Application no: H16-0288-11

Description: Alterations and extensions to existing two-storey dwelling to form two separate apartments

Location: 45 Bourne Road
Spalding
Lincs
PE11 1JN

Amendment: Amended car parking layout

AMENDED PLAN
Ref. <u>A 2</u>

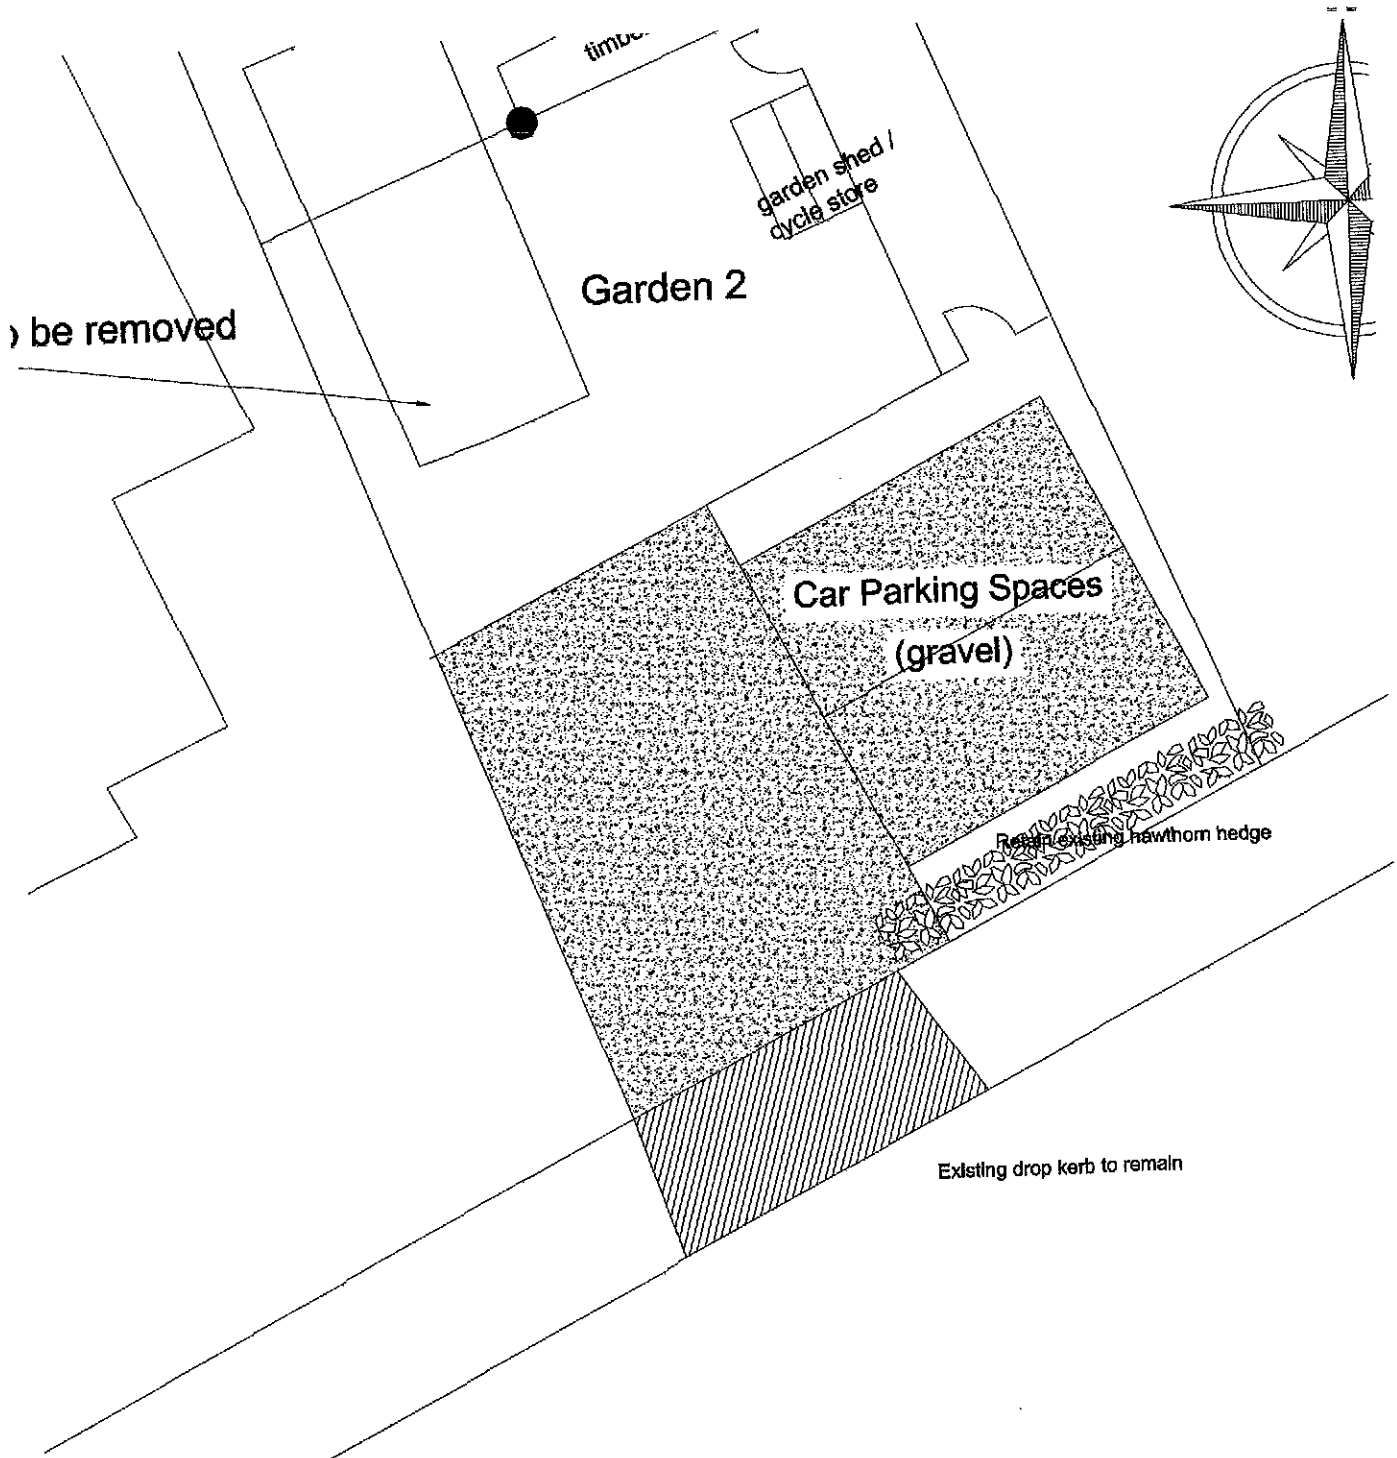
From: Crew, Chris
Sent: 16 May 2011 11:16
To: Porter, Karen
Subject: FW: PARKING AMENDMENT - 45 BOURNE ROAD
Attachments: 45 BOURNE ROAD - ENCHANTMENT HOMES.zip
Please book in extract drawing only as amendment - amended car parking layout

I have been to site and agree with your suggestion re: parking. I attach a revised drawing and a 1:100 A4 extract, so that you can print whichever you like. Please supersede the original parking proposals with those now shown.
